**HORSLEY DRIVE BUSINESS PARK –
Response from Western Sydney Parklands Trust dated 12-September 2012**

COMMENTS ON HORSLEY DRIVE BUSINESS PARK – COSTIN ROE
CONSULTING CIVIL ENGINEERING REPORT BY CATCHMENT MANAGEMENT
BRANCH (18 SEPTEMBER 2012)

Figure 5.1. Outlet Structure Components

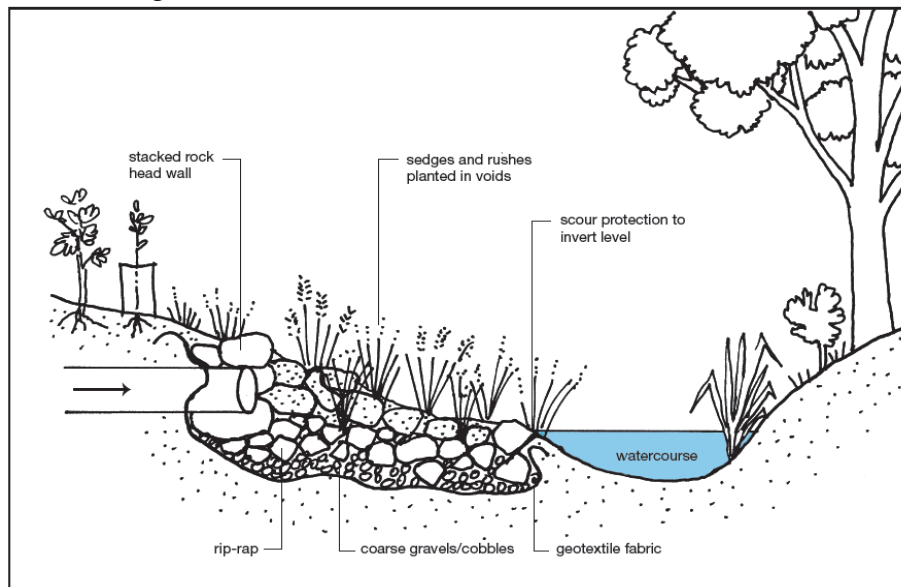
5.3.3	13	The NSW Office of Water document 'Controlled Activities: Guidelines for Outlet Structures' is not a design manual, only a design guideline. A more relevant design guideline should be reference. One example is the Catchments & Creeks <i>Rock sizing for single pipe outlets</i> August 2011

5.3.5	13	The outlet structures guidelines found within the blue book are for temporary structures, and are not appropriate for this situation.
5.3.5	13	Need to ensure the peak flow rate from the catchment are being used as the flow rate to size the rock protection

DRAWING TITLE: CONCEPT STORMWATER FINISHED LEVELS PLAN SHEET 1
DRAWING No: C011492.00-DA4-1-1

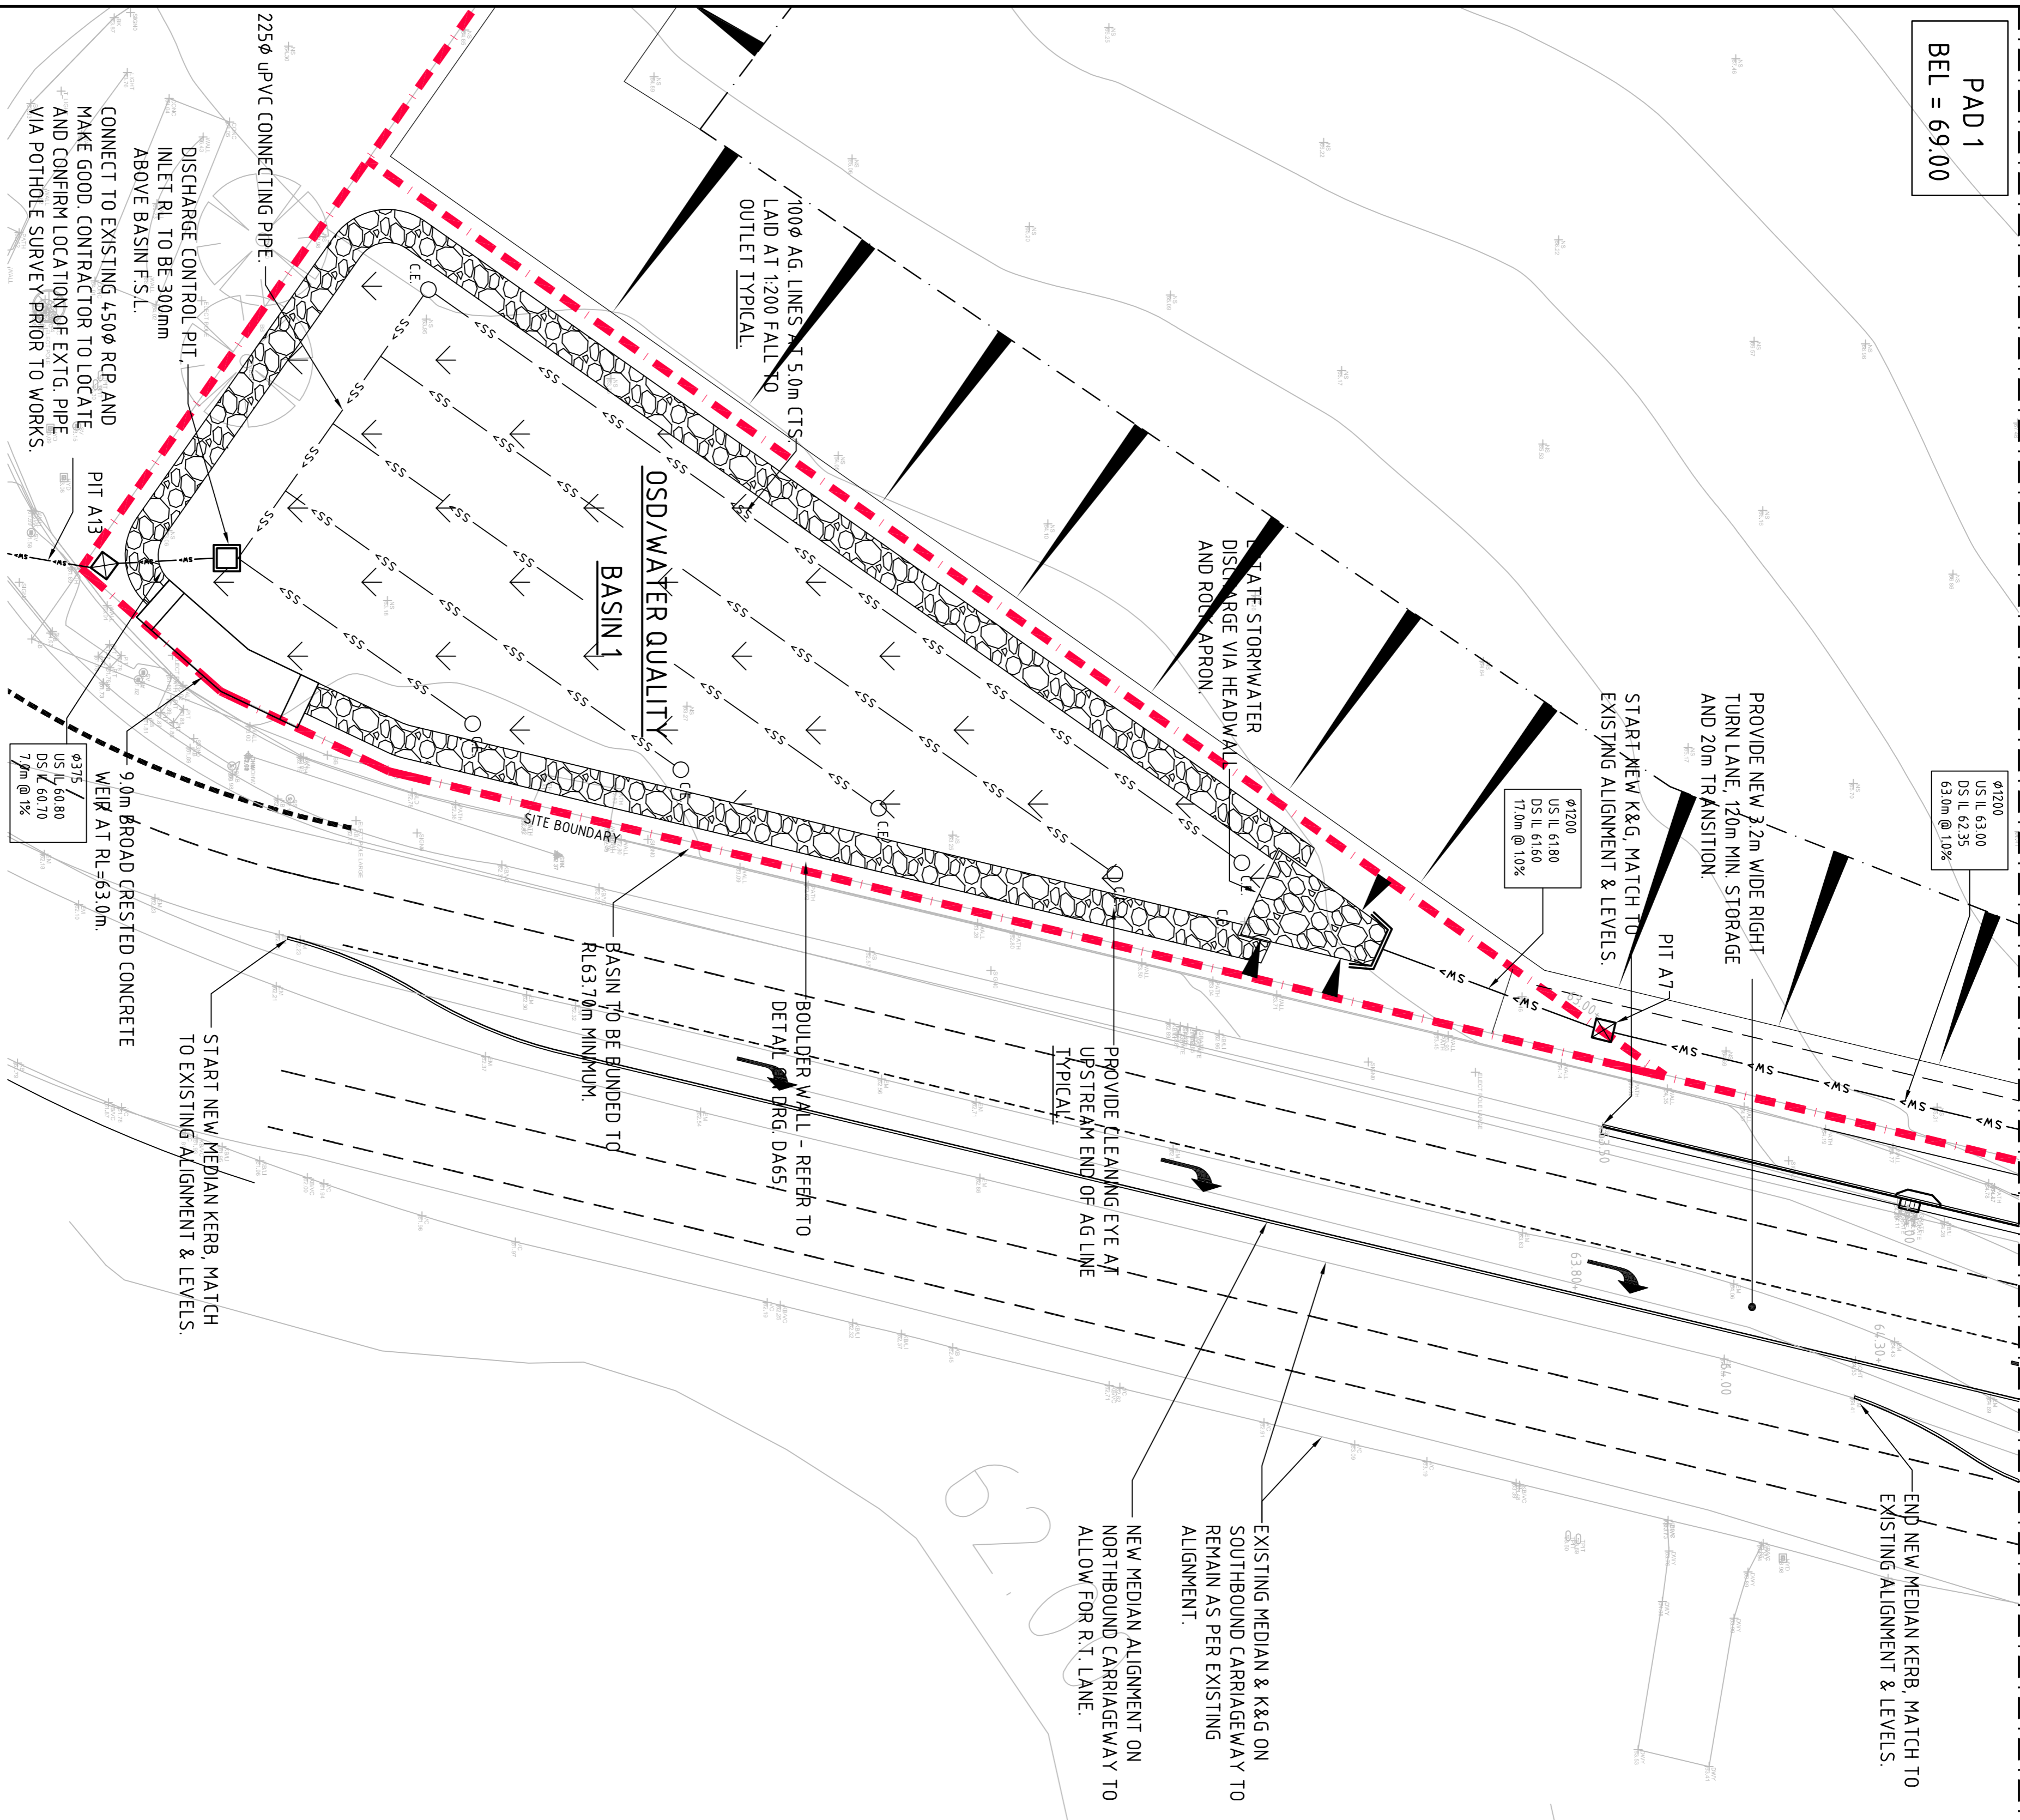
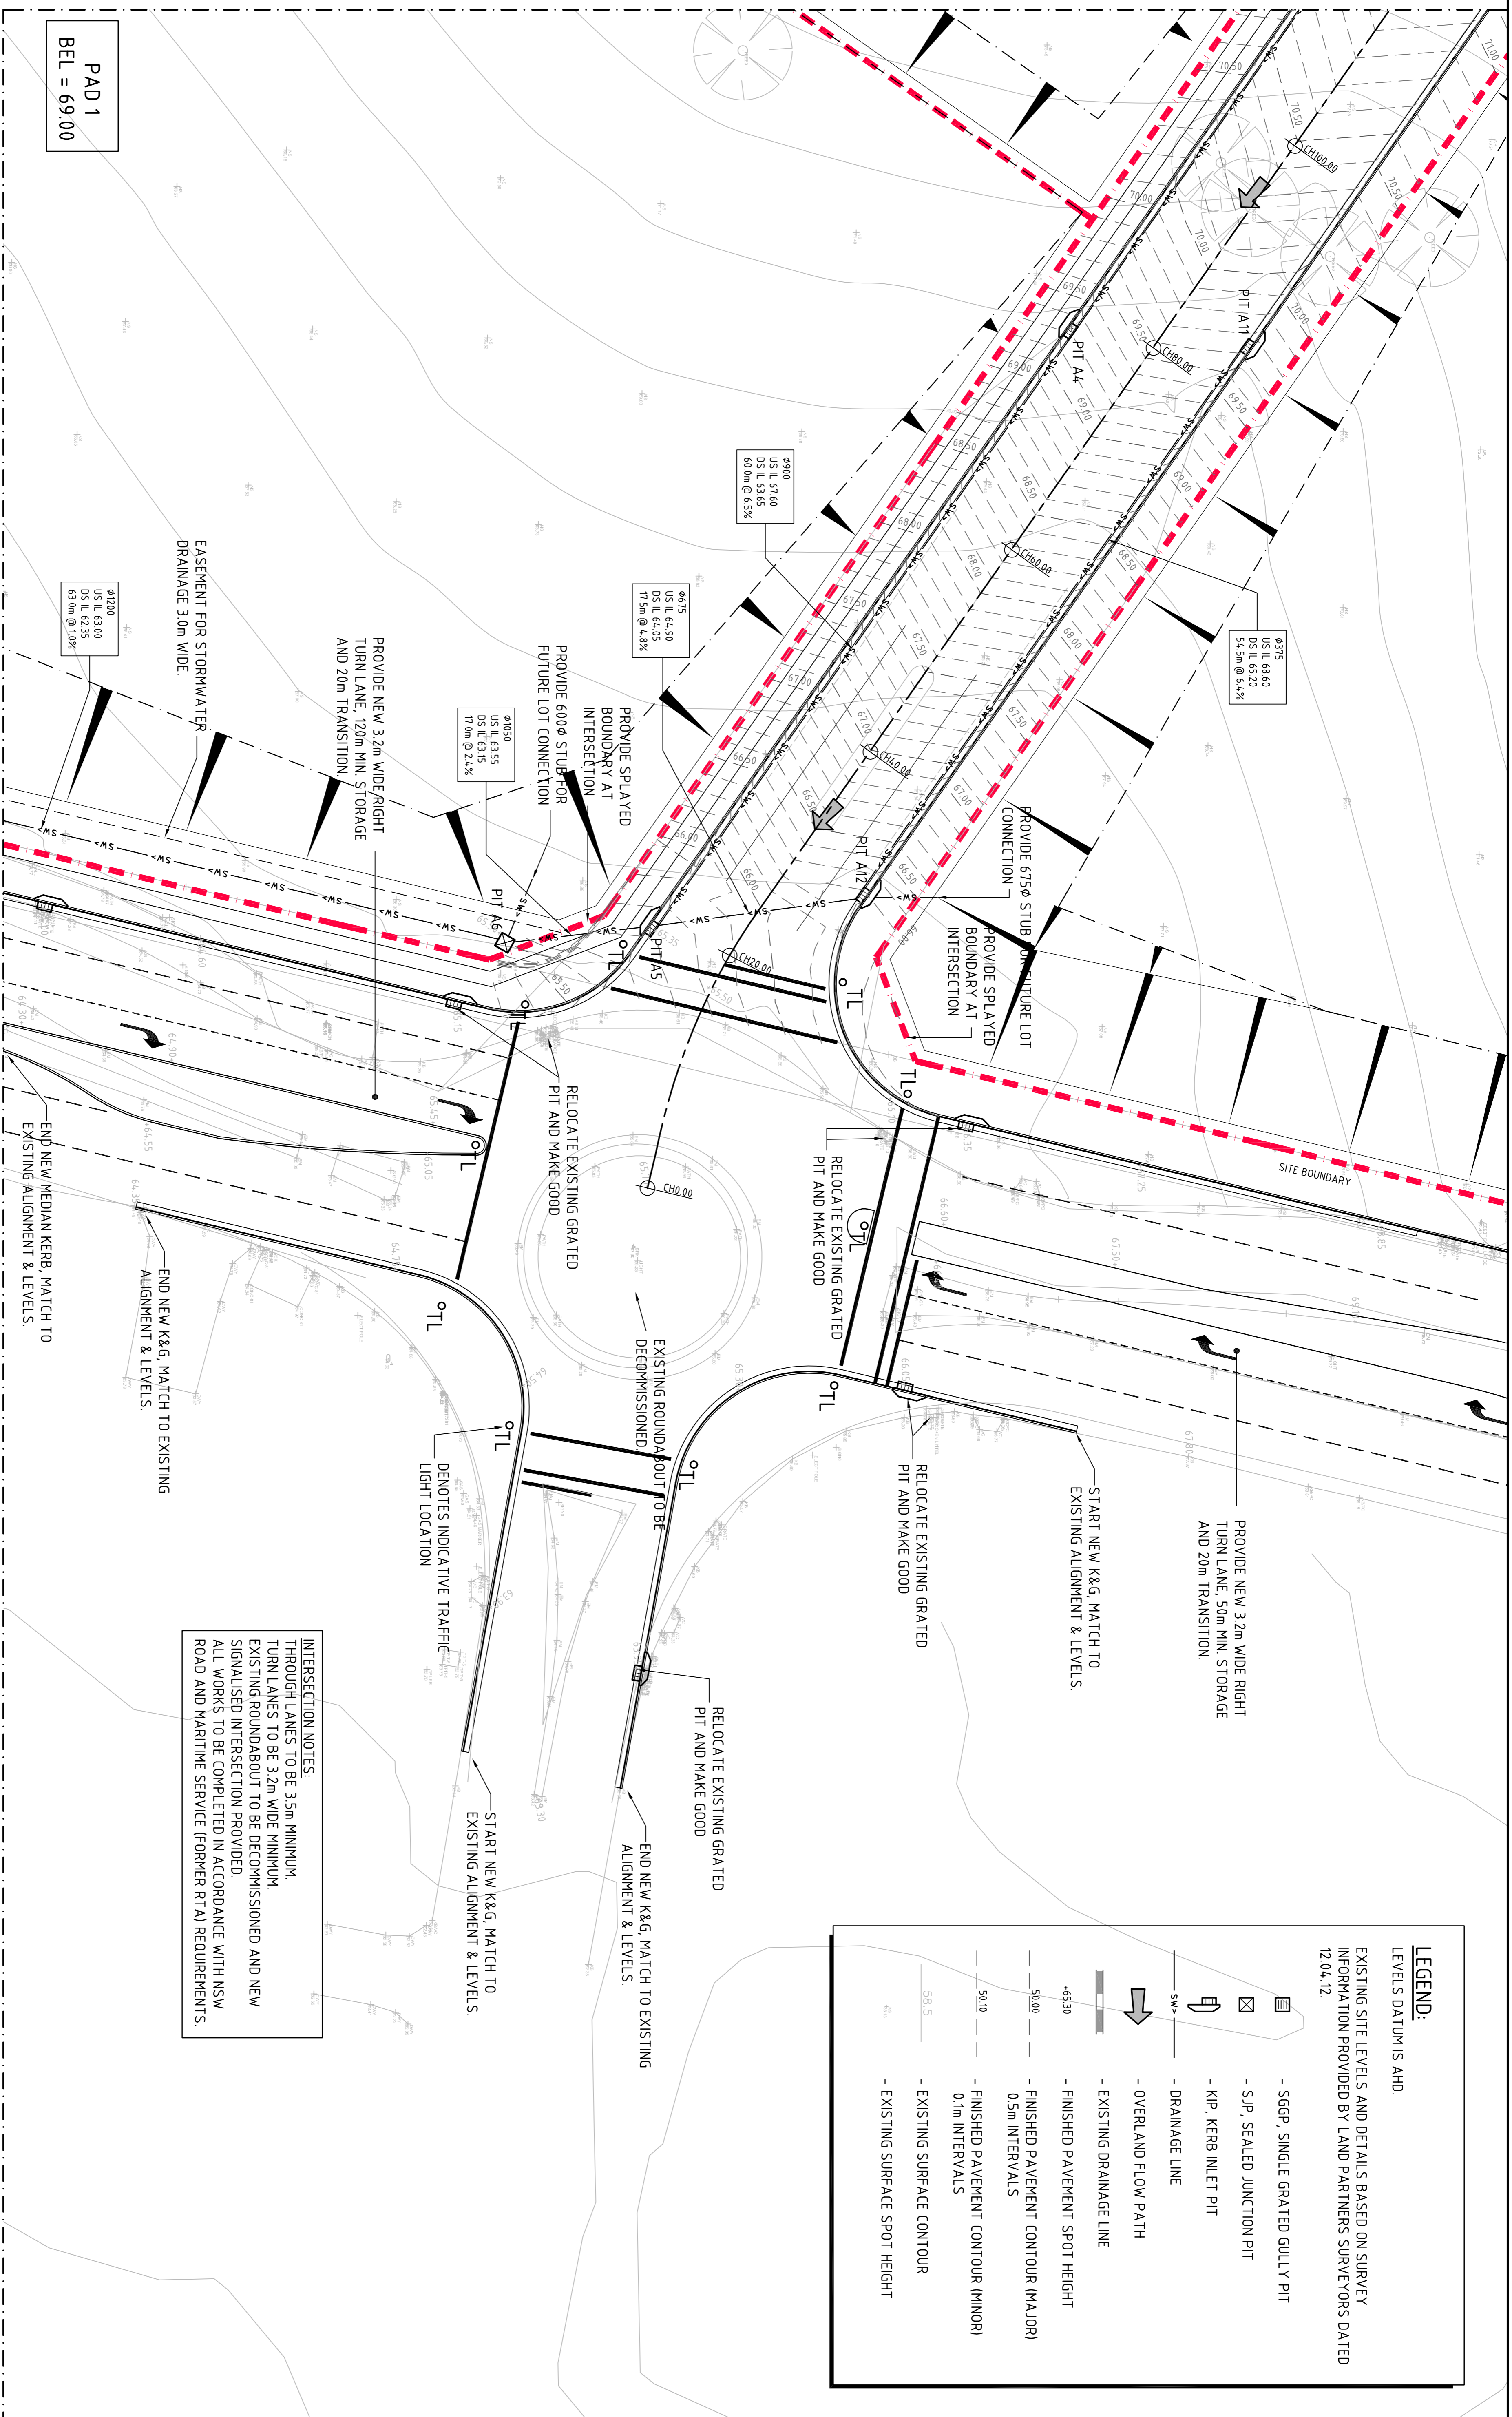
5.4	14	Need to ensure that there is sufficient grade on the overland channel around northern extent of the development. Please provide calculations undertaken to ensure the channel is sufficient.

5.6	16	Details need to be provided with respect to the outlet configuration of both of the basins to ensure they are in compliance with Councils OSD policy requirements.
5.6	16	Do the calculations for OSD include the western undeveloped catchments, as per modelling of flooding at the intersection of Cowpasture Road and Victoria Street.
